# **Hinckley & Bosworth Borough Council**

## **Deadline 6 Submission:**

**Application by Tritax Symmetry (Hinckley) Limited for an Order Granting Development Consent for the Hinckley National Rail Freight Interchange**

**(ref. TR050007)**

Written Statement of Oral Case ISH6 [Appendix C – Plan for A47 link road footway/cycleway design]

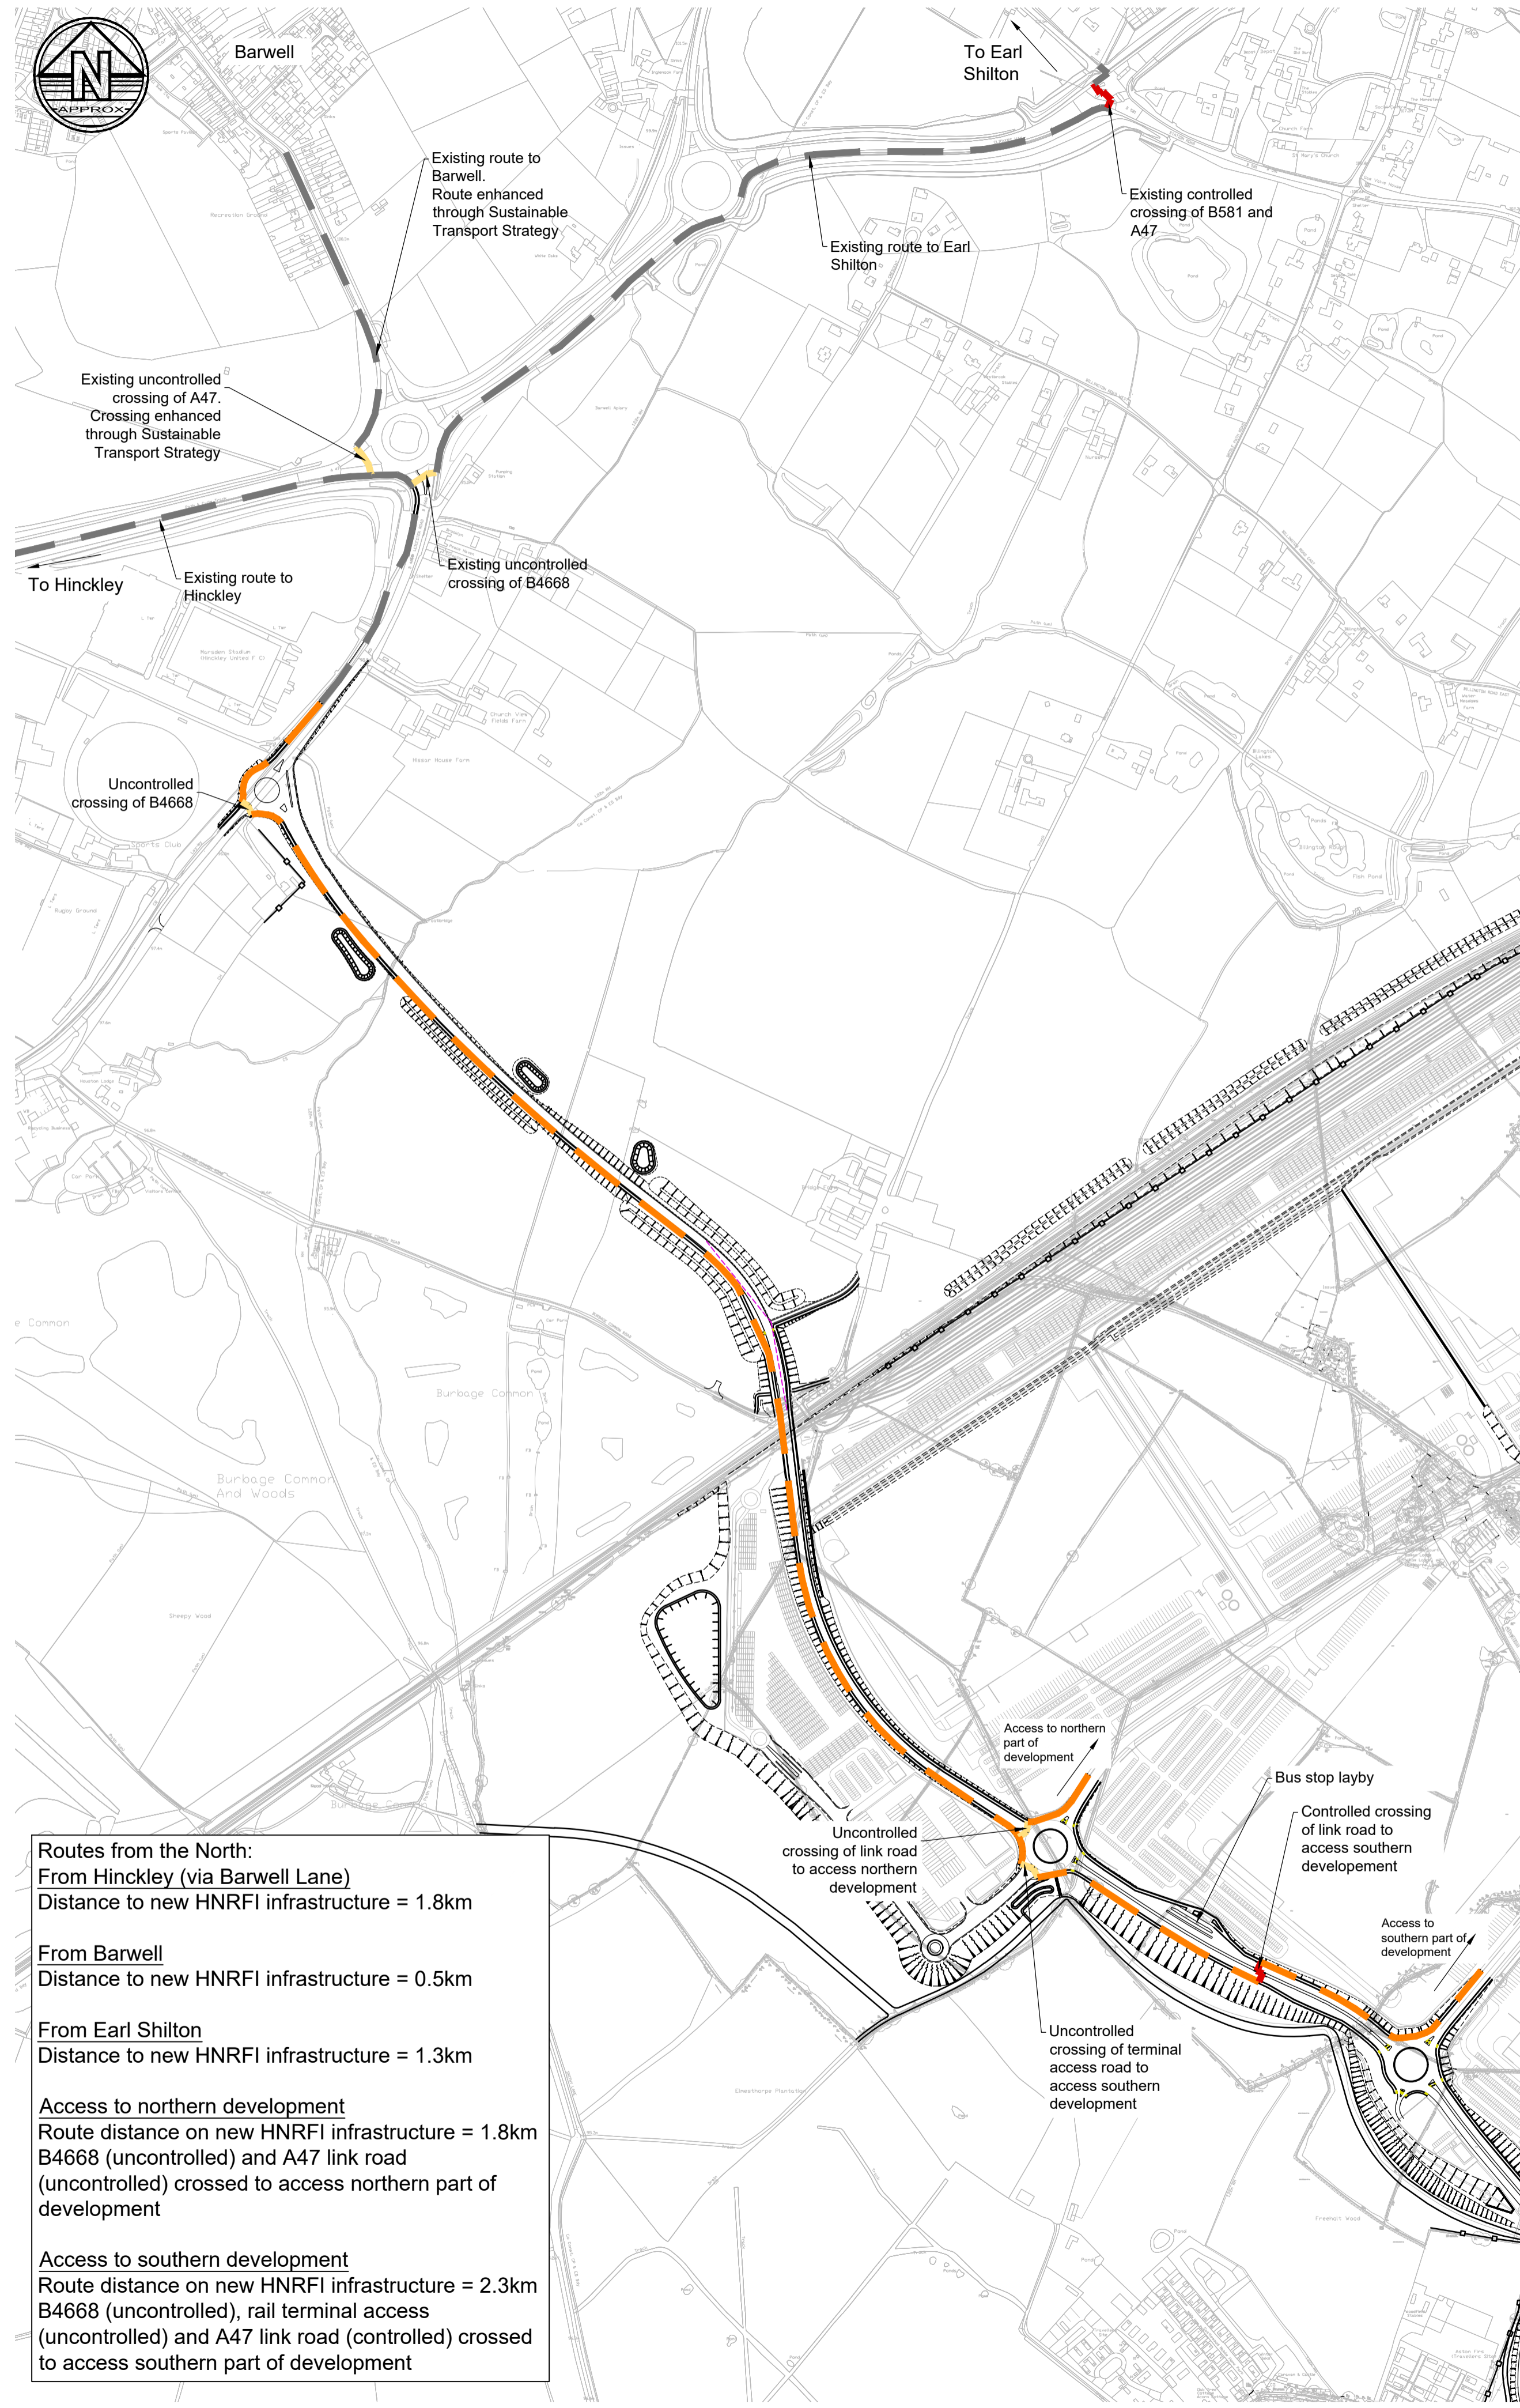
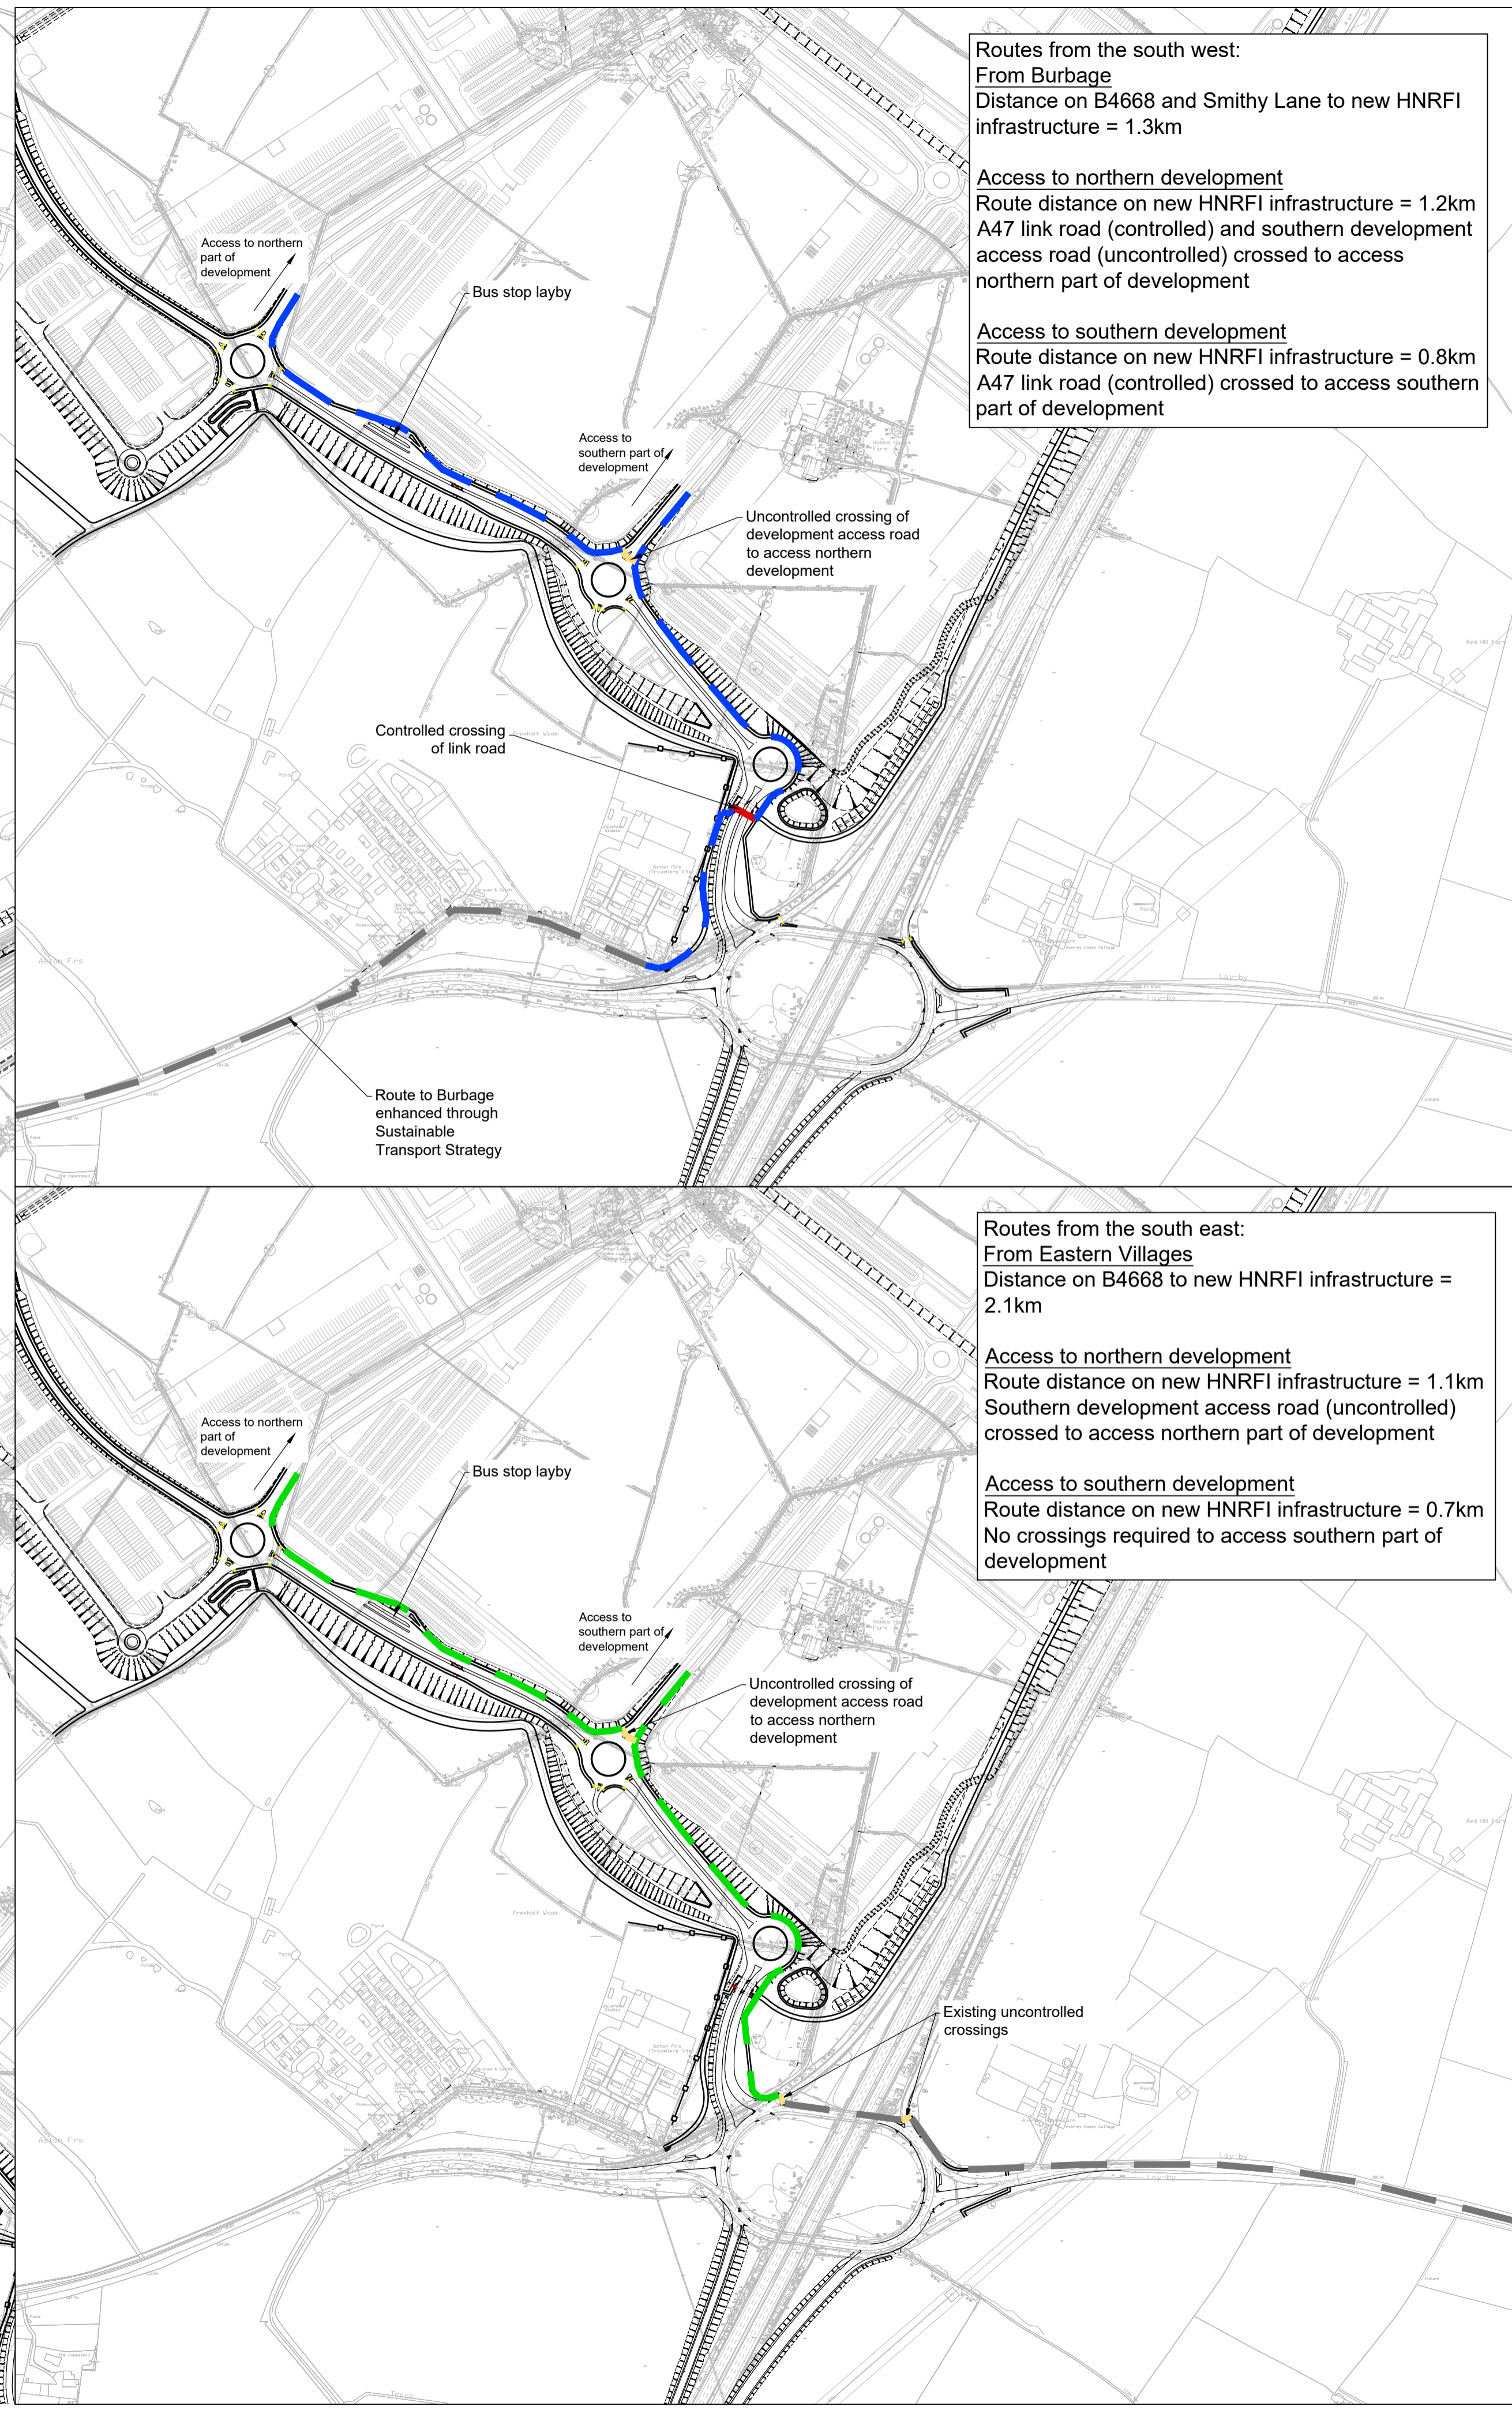
10. **A47 footway/cycleway** There is a reference to '*further connections will be included as Estate road*' – the Council requests that this be clarified; will this mean cyclists using the estate roads with other traffic or some form of shared/segregated safe facility?

10-13 **proposed cycle enhancements** – HBBC have already commented at Deadline 5 on the shortcomings of these proposals and recommended requirements. These facilities should be provided before first occupation as stated at Deadline 5.
